Lime Down Solar Park

**Planning Inspectorate Reference:
EN010168**

**Wiltshire Council Comments on Submissions
Received at Deadline 4**

Deadline 5 (7 August 2026)

Title:
Figure 13-5: Abnormal Load Routes: Solar PV Sites

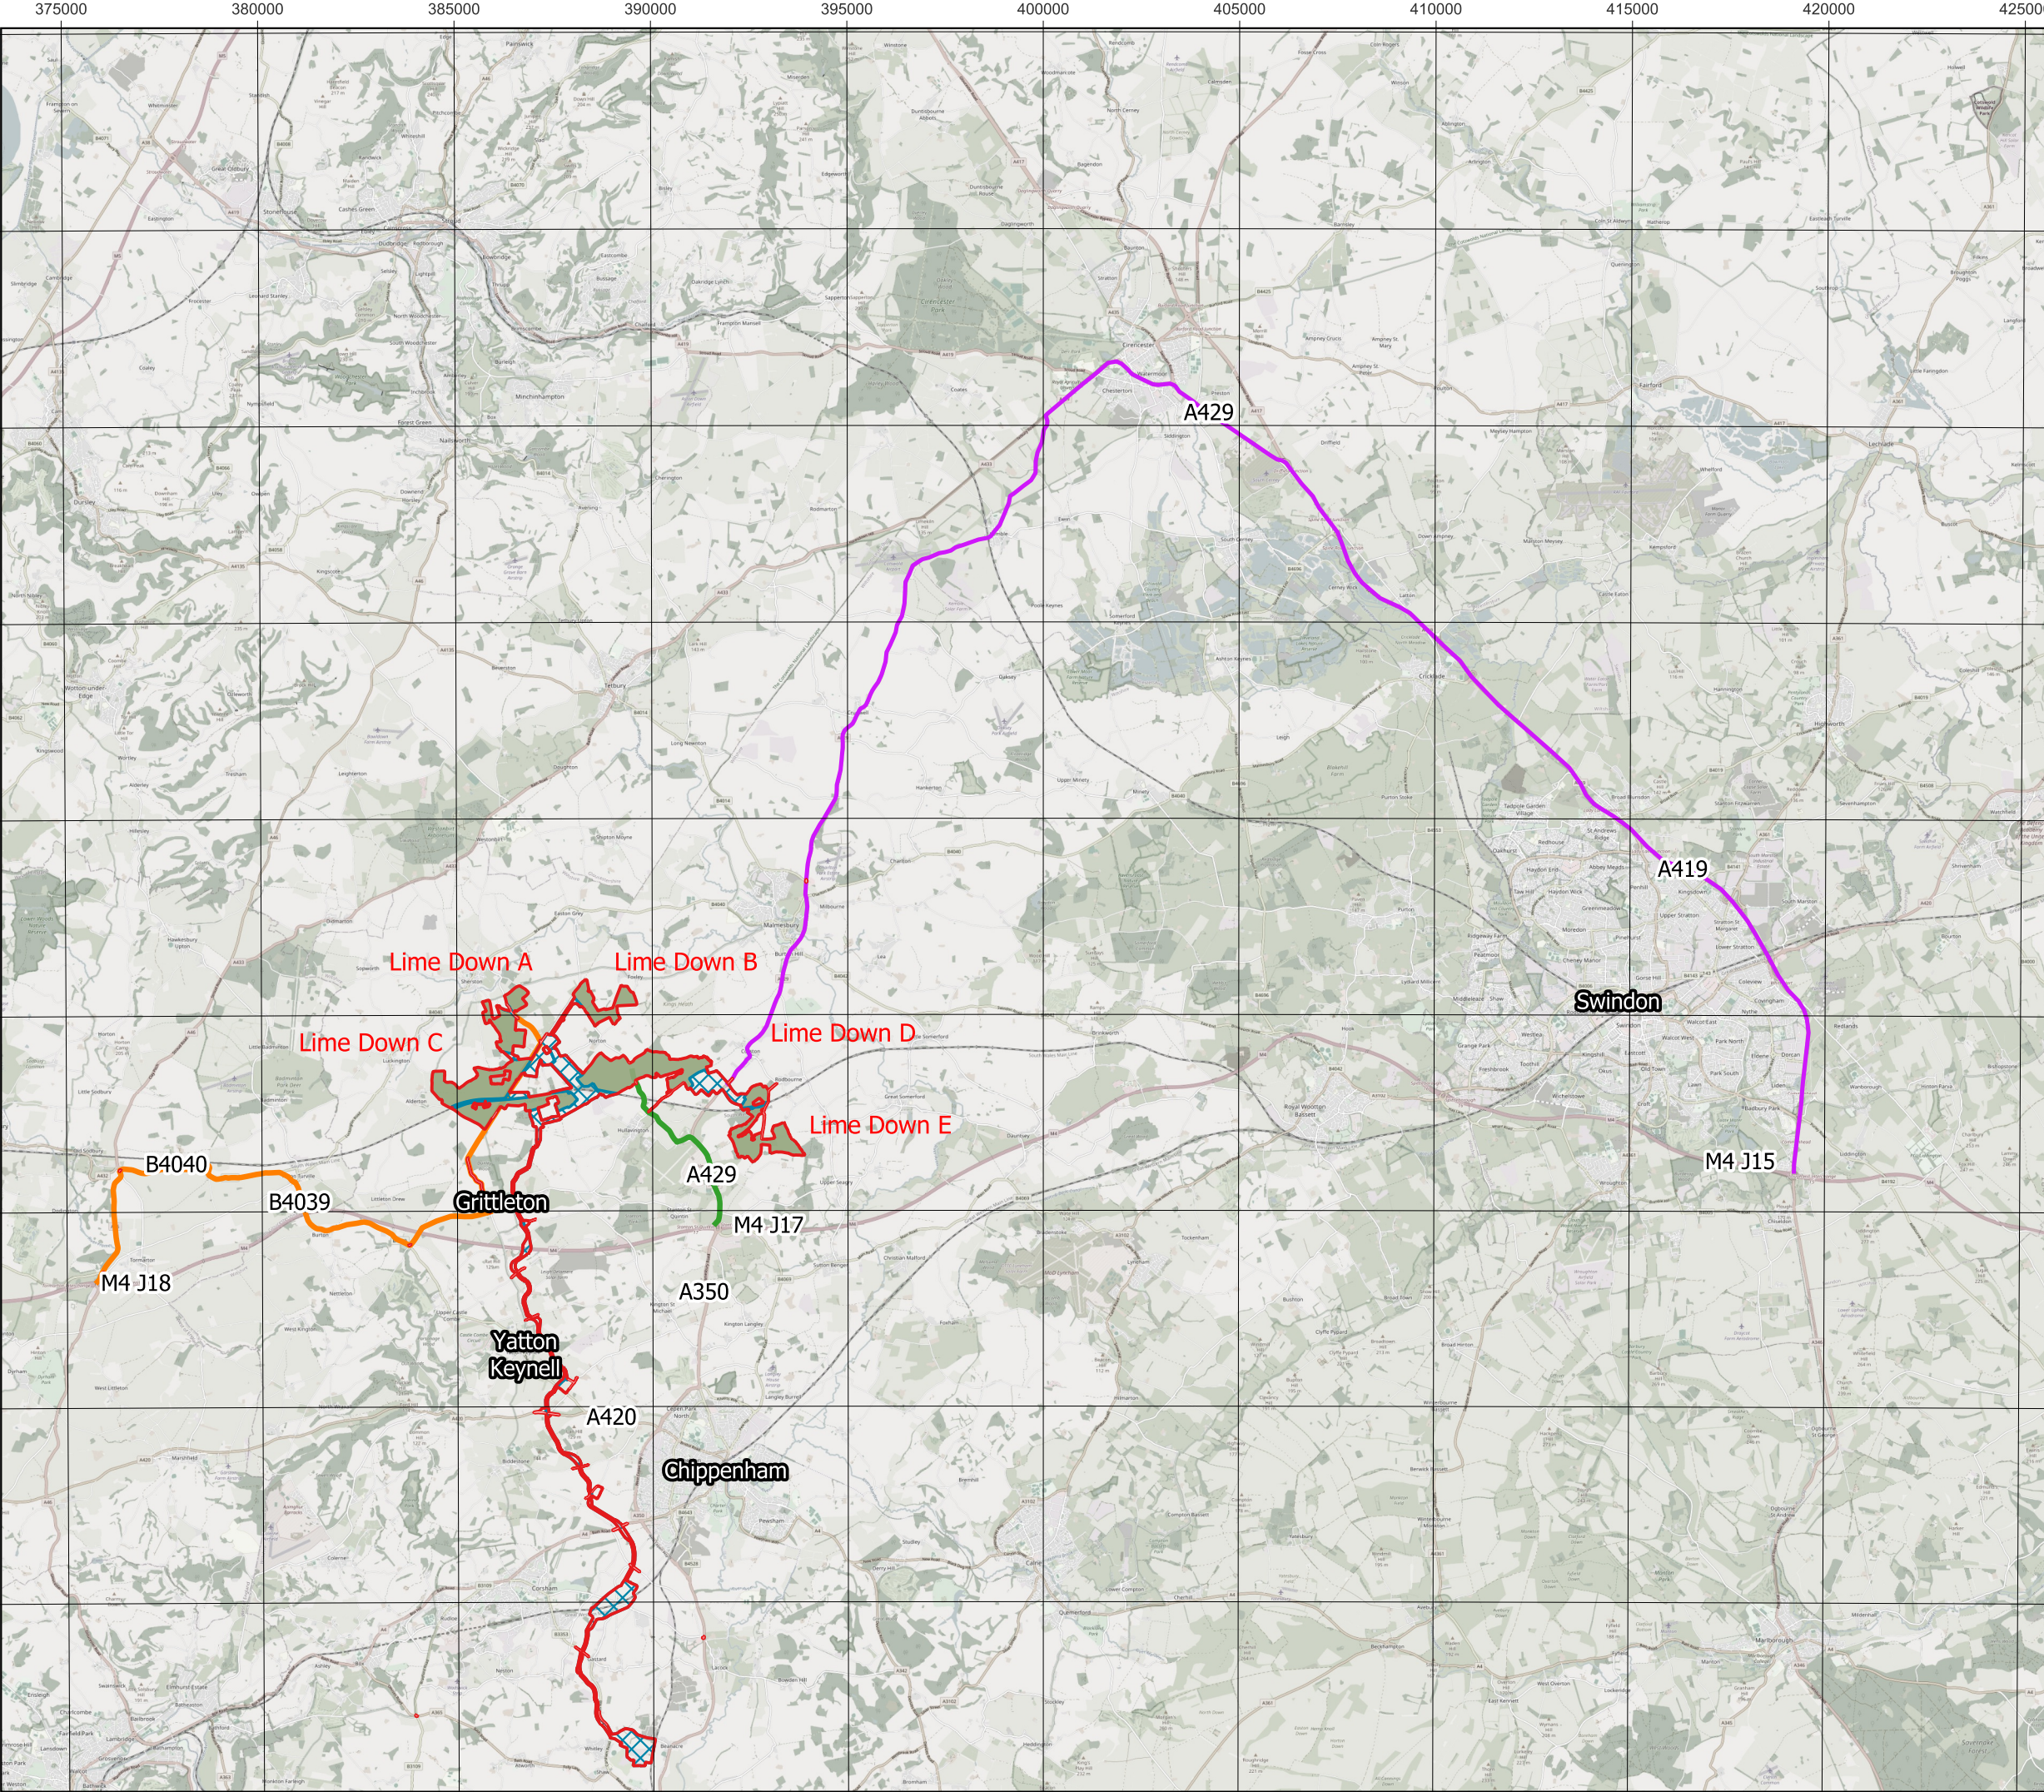
- 6.1. The council's Highways Development Management officer has no specific comments on this document. It is accepted that the purple route is needed to access Lime Down D (East) and Lime Down E because of the height constraints imposed by the railway bridge over the A429.

- 1:2,500 @
-
- LIME DOWN SOLAR PARK**
Figure 3-4-5.1
Lime Down Solar Park - Site E Sheet 1
Landscape and Ecology Mitigation Plan - Revision 4
EN010168/APP/6.2
5(2)(a)

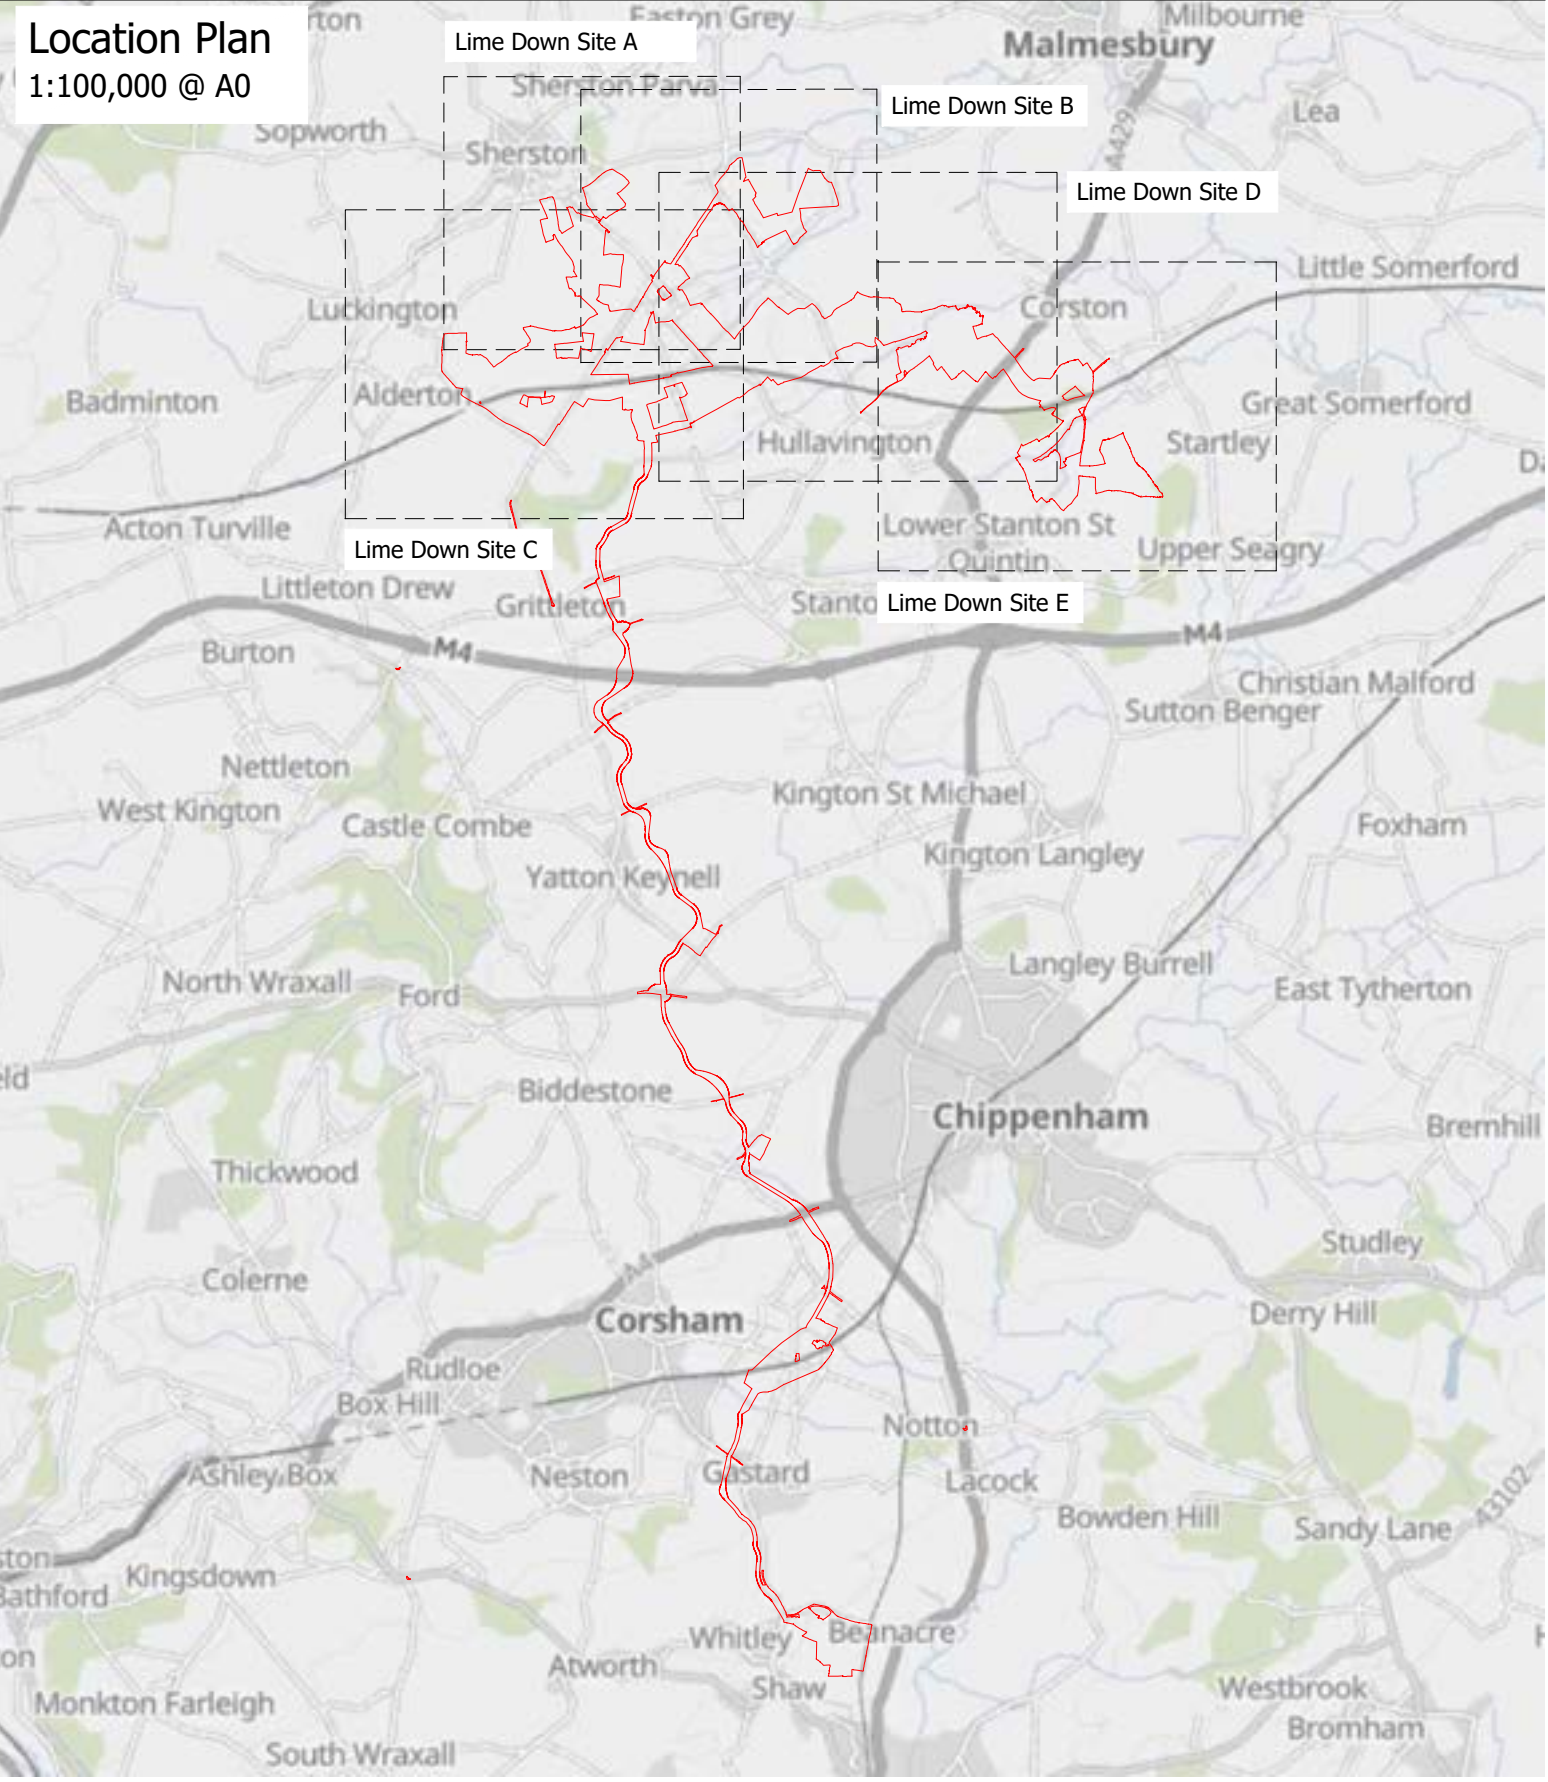
- 5.1. The Applicant's Deadline 4 Cover Letter [REP4-001] states that the figures have been updated to reflect amendments to the Bincombe Wood access track. It is noted that a new proposed access track routed to the north of and away from North Bincombe Wood as discussed with the Applicant's environmental, ecological and arboricultural consultants in a meeting on 27th July 2026, is illustrated on the updated figure. The council welcomes the new proposal to create an alternative access track in order to avoid using the existing access track alongside the ancient woodland.

- 5.2. Nonetheless, it is noted that the existing access track alongside North Bincombe Wood is demarcated as a proposed access track on [REP4-016](#). This is a concern for the council as it appears to indicate that the Applicant does still intend to use this access track during construction and presumably also during operation despite proposing the creation of a new access track to be used instead of the existing access track next to the woodland. The resultant lack of clarity due to the provision of inconsistent information gives rise to a lack of certainty and assurance that the request of the council, namely for the existing access track not to be used except for hedgerow / vegetation maintenance, will be fulfilled. Furthermore, there are discrepancies in respect of the proposals in terms of usage of the existing access track next to North Bincombe Wood in REP4-011 as detailed above.

- 5.3. It is therefore requested and expected that the Applicant will provide further information to rectify and clarify the current inconsistencies observed across the recently updated documents and plans.
